Lead Local Flood Authority
Post Point CHN 215
Hertfordshire County Council
County Hall, Pegs Lane
HERTFORD SG13 8DN

Date 11 February 2022

**RE: 6/2021/2125/MAJ – Hertfordshire Constabulary, Stanborough Road, Welwyn
Garden City, AL8 6XF**

PROJECT NUMBER
 60600329
SHEET TITLE
 Proposed SuDS Sections

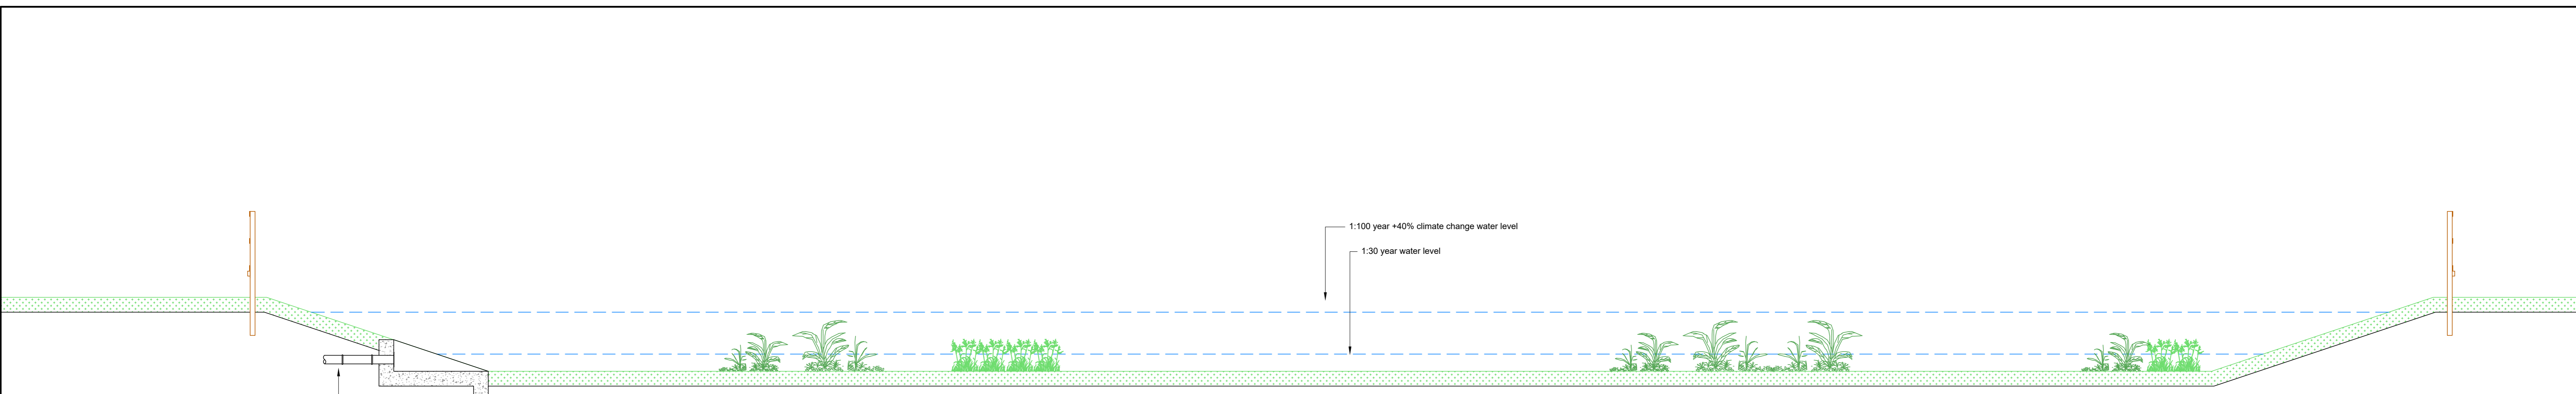
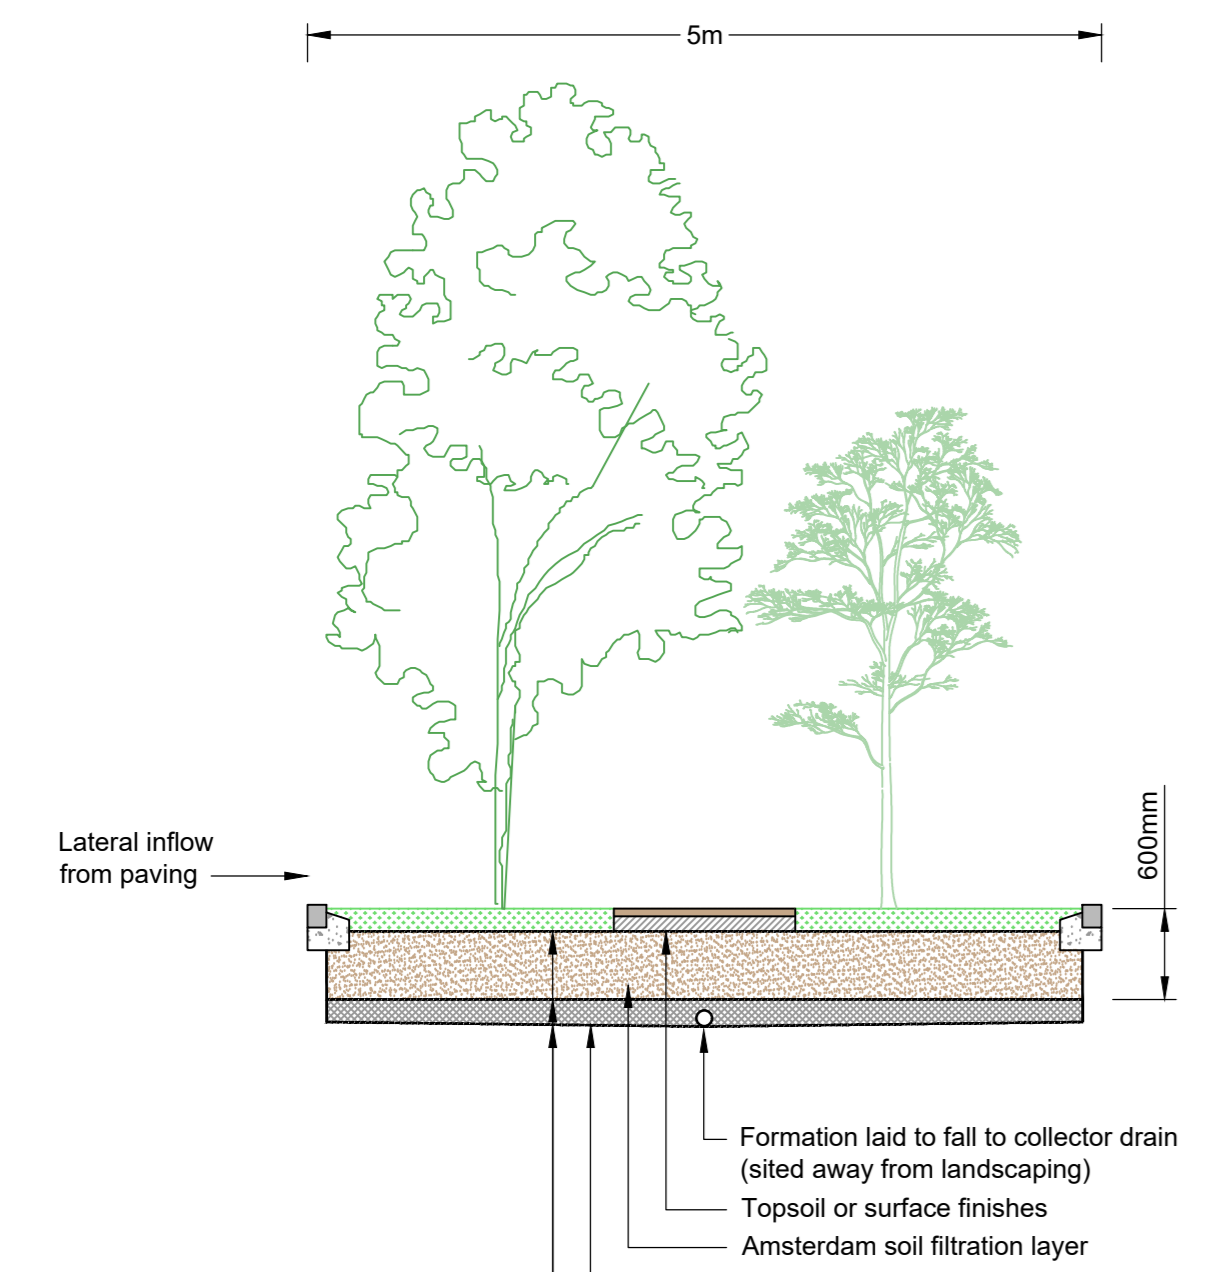
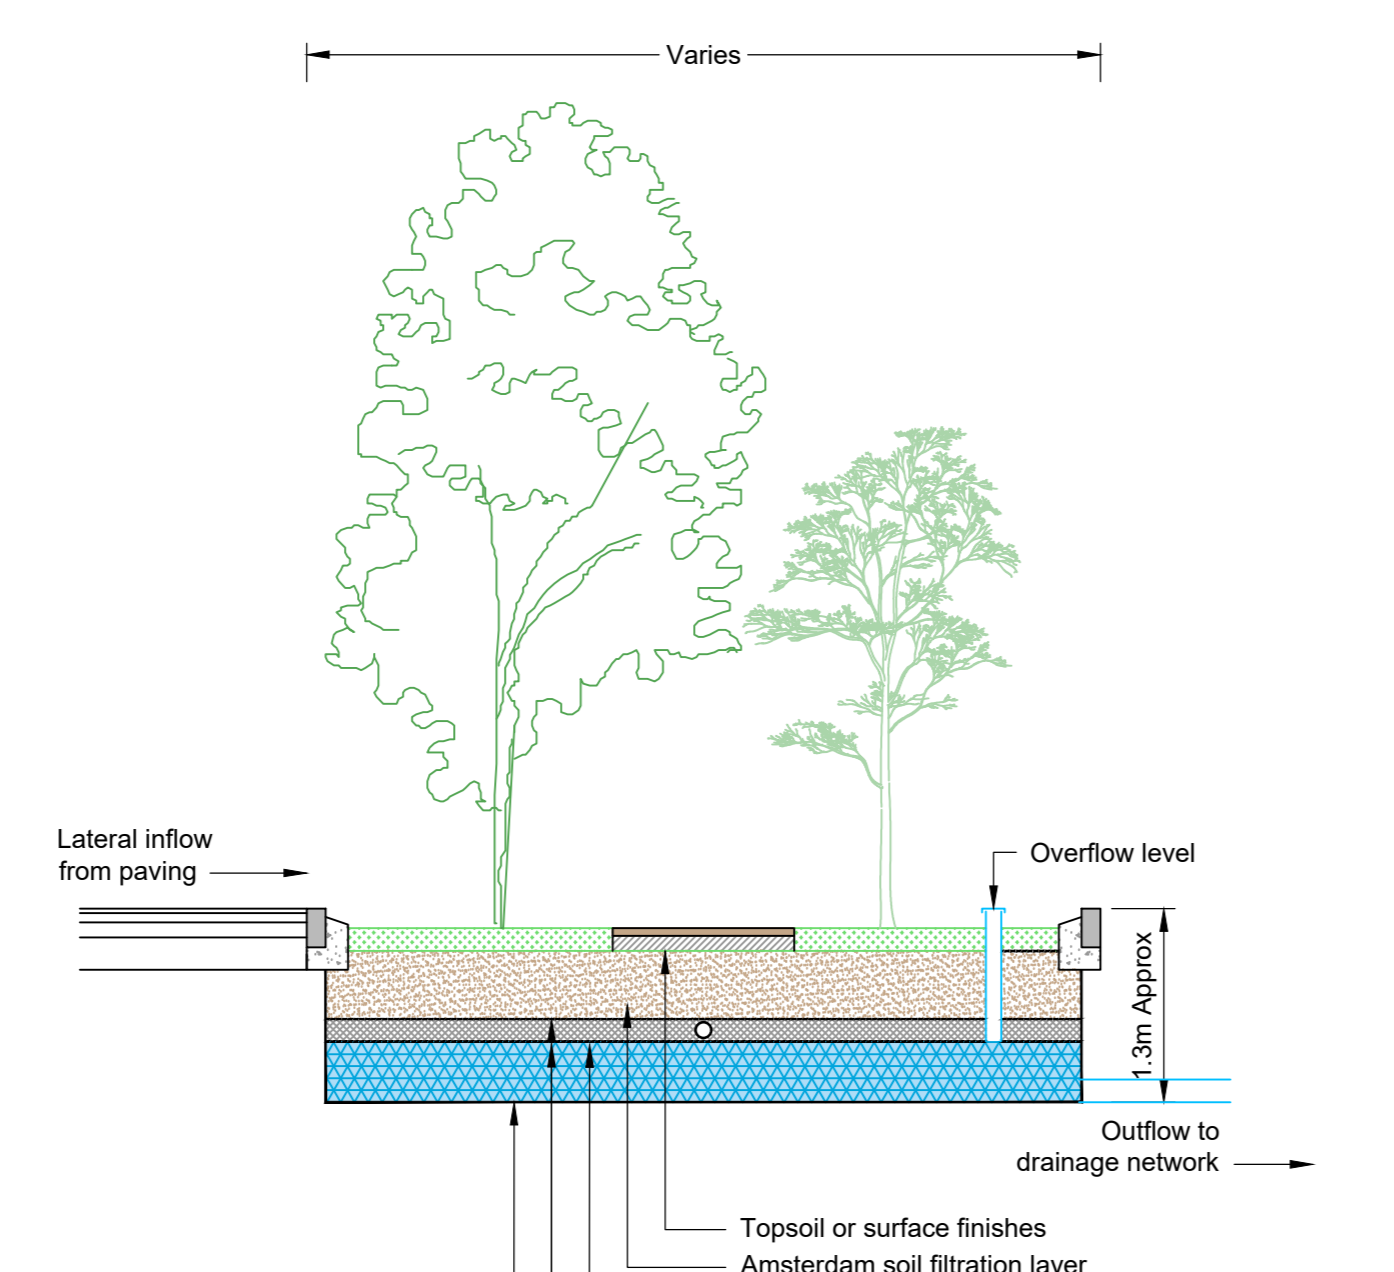
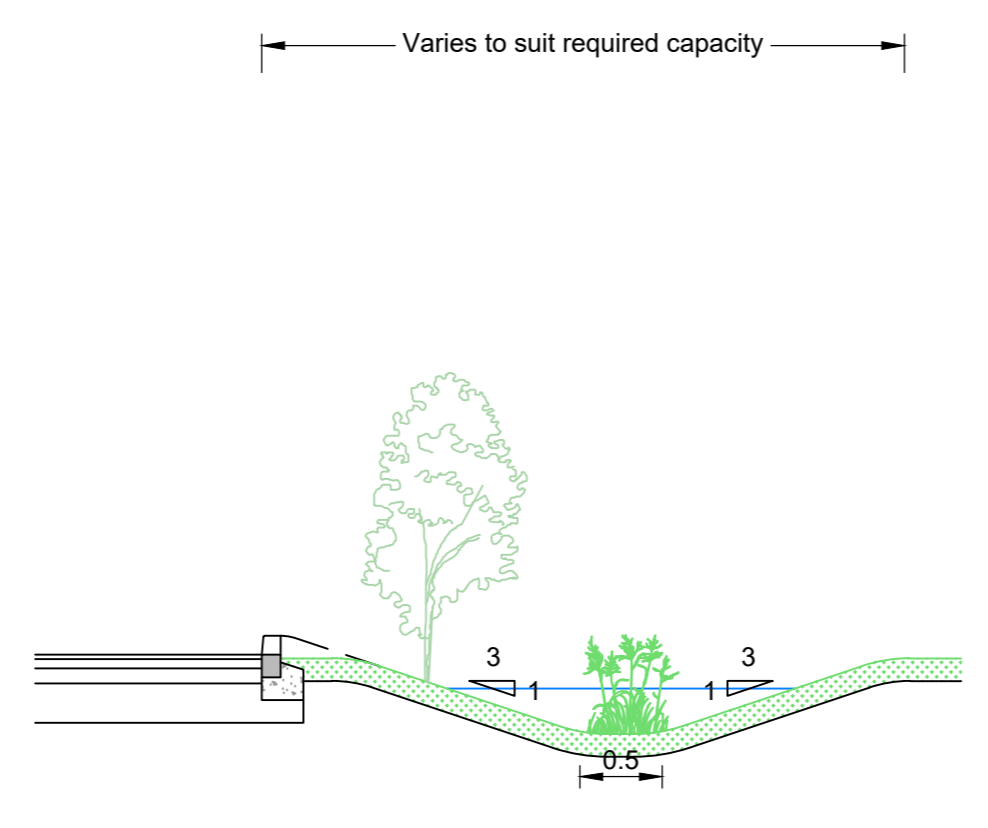
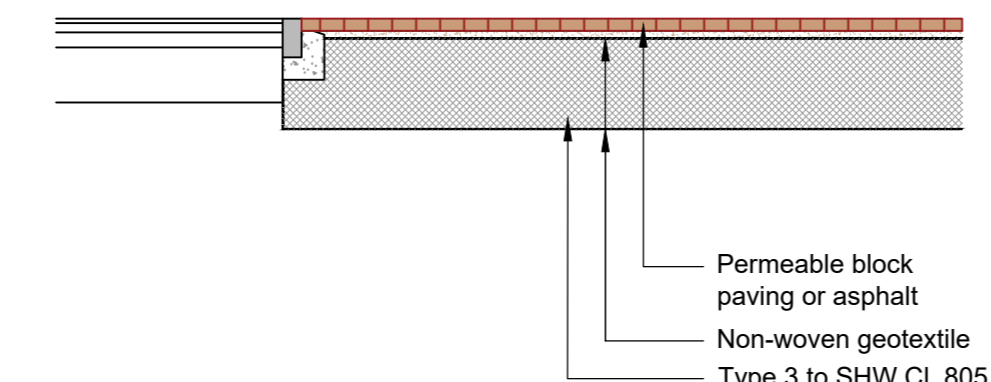
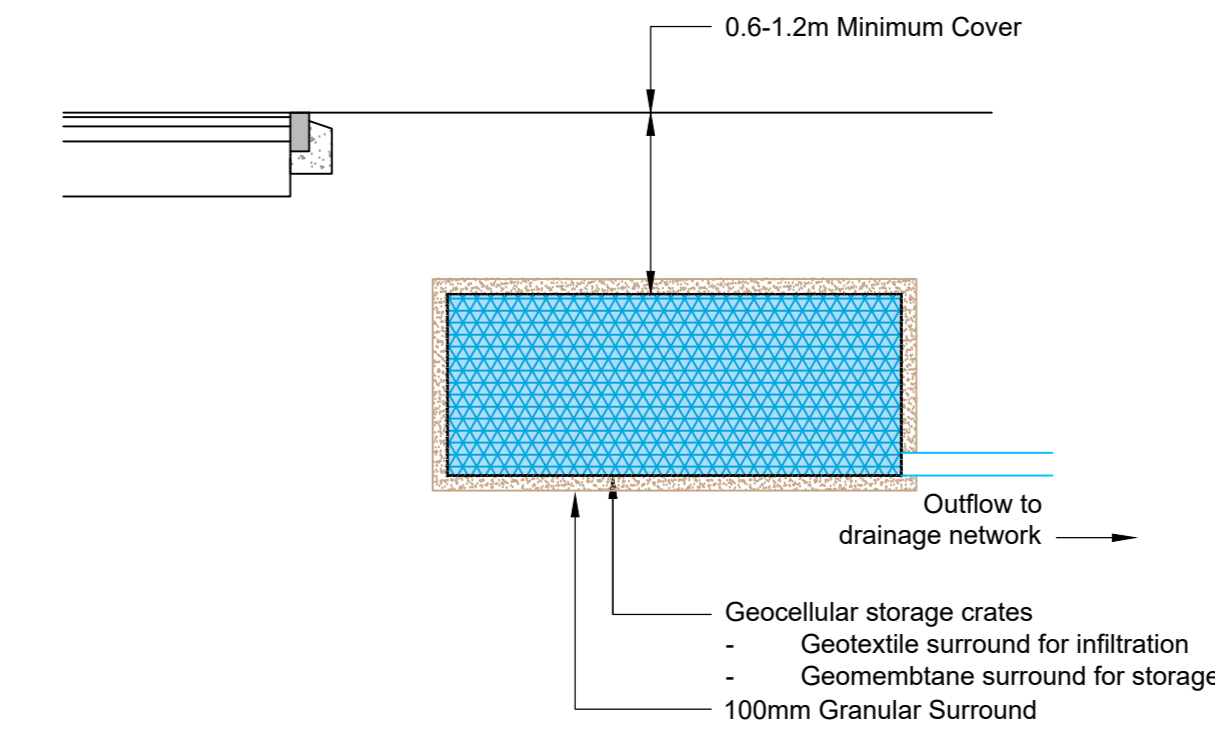
It is understood that the surface water drainage scheme for the proposed development utilises infiltration for the 1.4 ha of external paved areas and an attenuated surface water system that collects roof runoff and any other areas not utilising infiltration. The attenuation system will make use of an existing attenuation pond that is to be increased, with an ultimate discharge into a Thames Water sewer network through an existing connection. It is noted that where necessary underground attenuation will be provided, whilst this in principle would be acceptable priority must be given to above ground methods for surface water attenuation.

It is noted that there are two discharge locations for the areas not proposed to infiltrate. A new connection is proposed into an existing network at a restricted rate of 1.39 l/s and an existing connection into the attenuation pond with a restricted rate of 4.61 l/s. It should be highlighted how it is proposed to restrict the rate into the attenuation pond.

5. Detailed engineered drawings of the proposed SuDS features including cross section drawings, their size, volume, depth and any inlet and outlet features including any connecting pipe runs.
